From: Martin Hill <Martin.Hill@arun.gov.uk>
Sent: 02 June 2020 13:35
To: Planning.Responses <Planning.Responses@arun.gov.uk>
Subject: RE: Planning Consultation on: BR/99/20/PL

Comments from Private Sector Housing:

Application No: BR/99/20/PL
Registered: 13th May 2020
Site Address: 23 Mead Lane Bognor Regis PO22 8AP
Grid Reference: 494025 99771
Description of Works: Change of use from Student Accommodation to 3 No. dwellings, comprising 1 No. 1 bed apartment, 1 No. 2 bedroom house & 1 No. 3 bedroom house. This application affects the character & appearance of the Upper Bognor Road & Mead Lane Conservation Area & may affect the setting of a Listed Building.

PROPOSED FIRST FLOOR PLAN

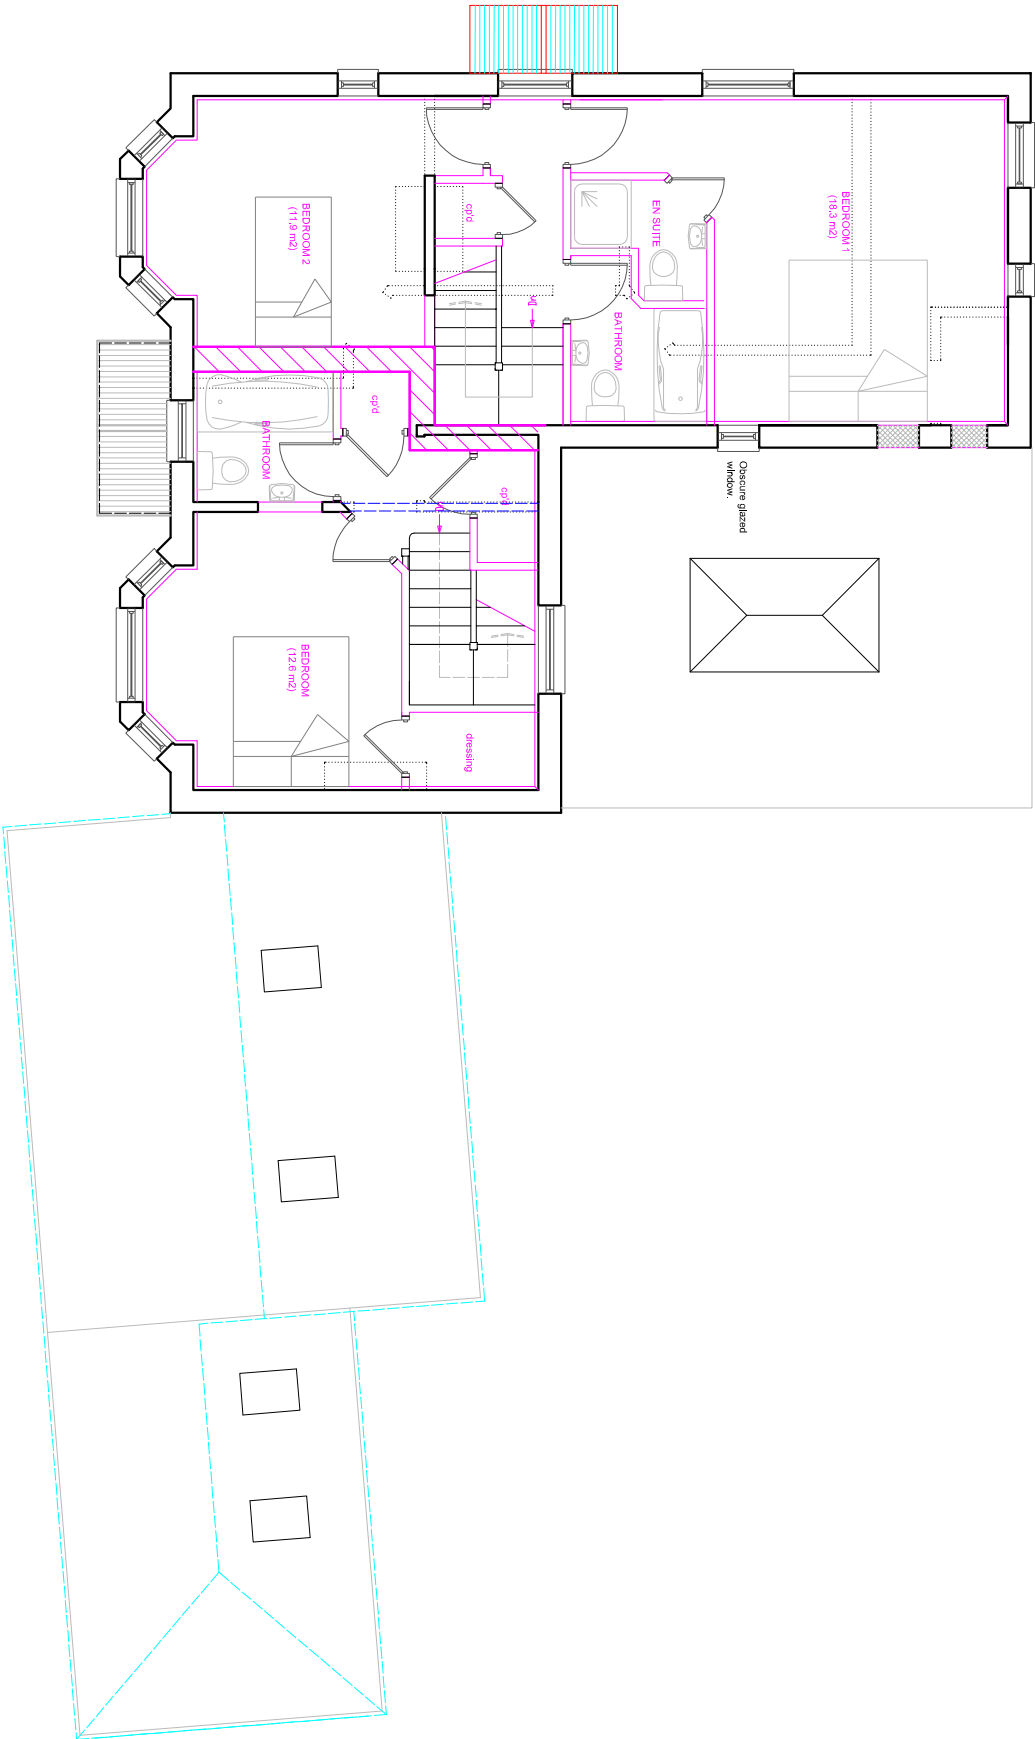
- Appropriate fire precaution facilities and equipment must be provided of such type, number and location as are considered necessary. Guidance on fire safety is contained in the LACORS guidance document – "Housing – Fire Safety, Guidance on fire safety precautions for certain types of existing housing"
- A room where the only escape route is through another room is termed an "inner room" and poses a risk to its occupiers if a fire starts unnoticed in the outer room. The escape route from the bedroom in Unit 3 is via the kitchen & lounge area. This can be overcome by ensuring that the window in the bedroom meets the

requirements of an escape window and additional fire protection in the form of an FD30S fire door between the bedroom and the kitchen/lounge area and interlinked smoke detection in the lounge and bedroom areas.

- Unit 1 and Unit 2 - Grade D, LD3 fire alarm and detection systems, as follows:
 - o interlinked mains wired smoke alarms with integral battery back-up located in the escape route on each level of units 1 & 2
 - o Fire blankets are recommended to be provided in each kitchen
- Unit 3 - Grade D, LD2 fire alarm and detection systems, as follows:
 - o As specified above for units 1 & 2, the same for unit 3 but with the addition of interlinked mains wired smoke alarms with integral battery back-up in the Lounge and Bedroom areas because of the inner room scenario. The fire alarm requirements for unit 3 will meet the requirements of a Grade D LD2 system, because of the additional detection.

- A close fitting, conventional door is required to all bedroom and risk room. The ground floor bedroom of unit 2 must be fitted with a close fitting conventional door.
- The floor to ceiling height must be at least 2.1 metres from floor to ceiling over at least 50% of the floor area when measured at a height of 1.5metres from the floor and provide sufficient useable space.
- Note with regards to children and how they fit into room size calculations:
Babies up to the age of 1 are discounted
Children aged 1 -10 years are classed as half a person
Children aged over 10 years are classed as a person

- It is proposed that obscured glazing will be installed in unit 3's bedroom. All rooms should be provided with windows that provide a reasonable view, unless where privacy is required in Bathrooms and WCs, for example. In this instance the proposal can be accepted in view of the single bedroom and the occupant(s) having sole access to other areas of the unit which do provide windows with a reasonable view. It should be noted, however, that in most cases and where reasonably practicable and non-detrimental to the occupants of the dwelling, windows with a reasonable view should be provided.
- An escape window with a sill height of not more than 1100mm from finished floor level, with an unobstructed openable area of 0.33m² and have a minimum 450mm height and 450mm width must be provided in the bedroom of unit 3.
